A556 Consultation Process

This letter contains my objections to the consultation process for the scheme to build a new set of roads to replace the current A556 that currently provides a link from the M6 to the M56. Please register me as an interested party and send communications to me email address or my home address

Cuttings and embankments

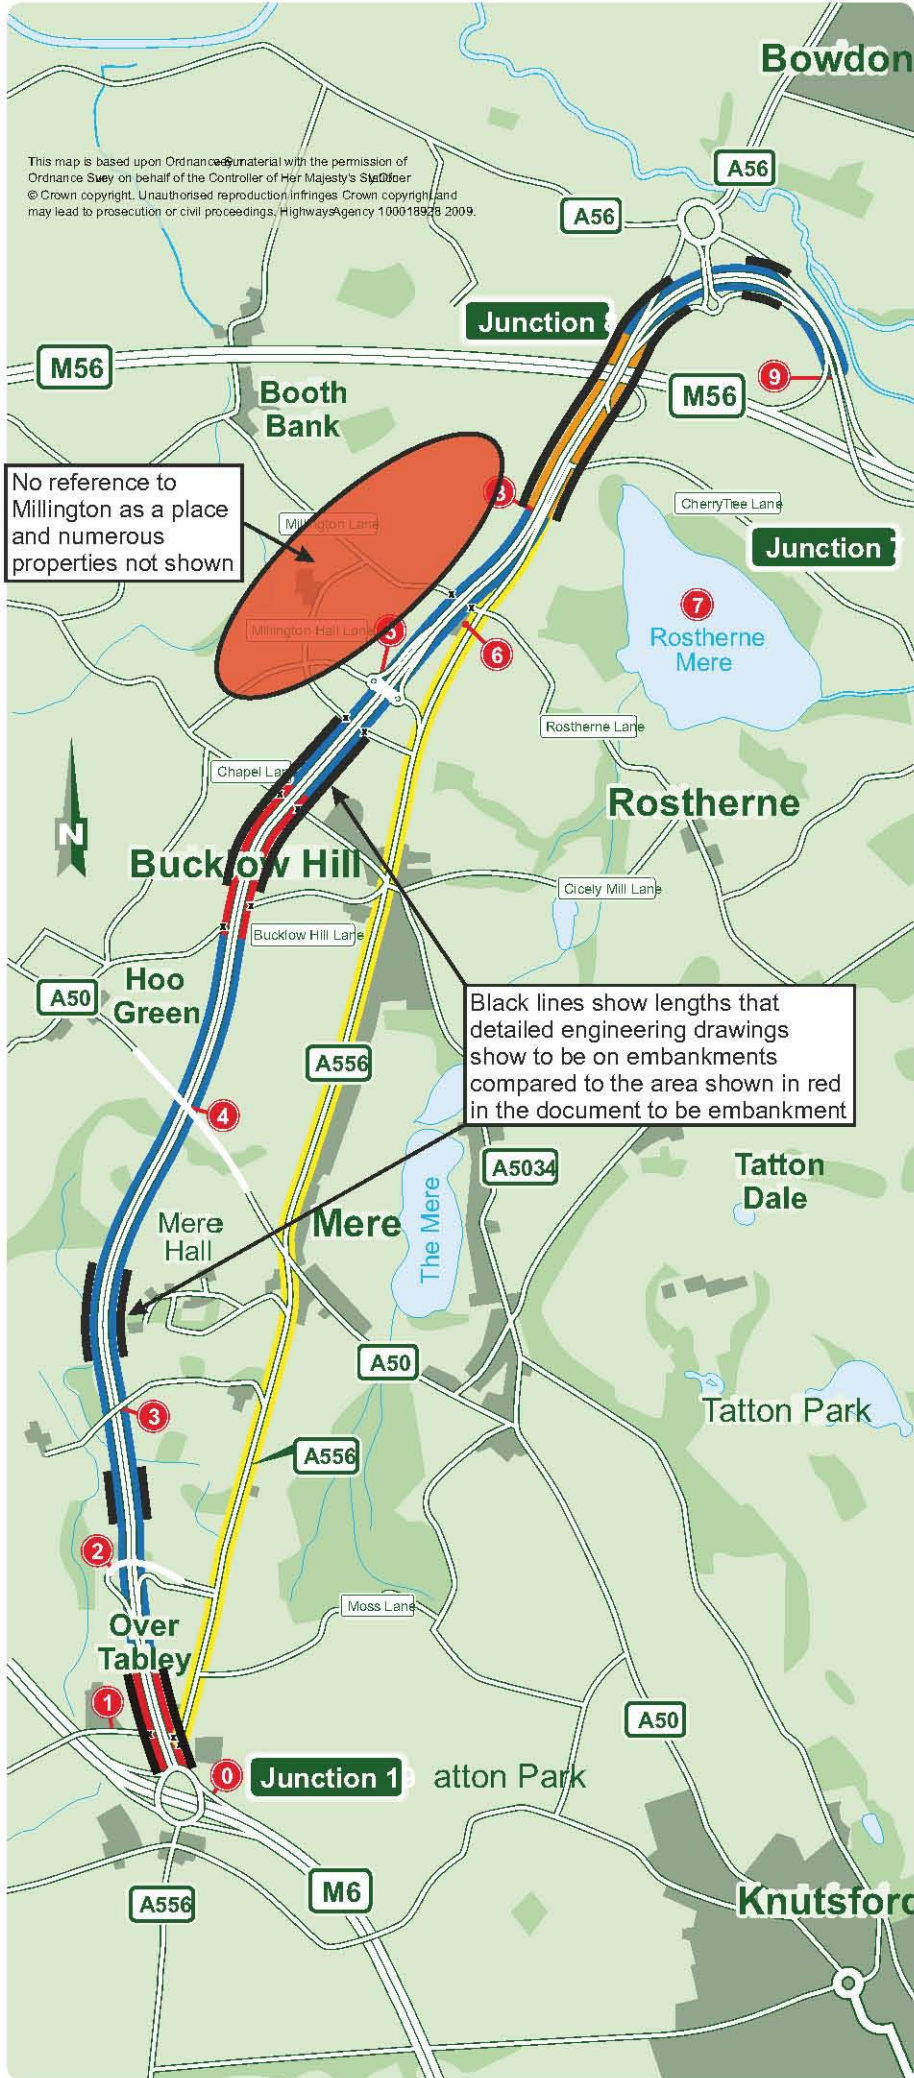
1. At the recent meetings to show the road "design" and options it was apparent that the diagrams / plans failed to show many of the houses on the route. The consultation questionnaire is therefore misleading with regard to both the environmental and social impact of the plans.

8. Why are the original cuttings off the design? I chose option other because none of the options are acceptable.
9. Currently the flow of traffic onto the M56 is part controlled by the traffic lights on the A556. As these lights disappear there will be a huge build up of traffic at the M56.
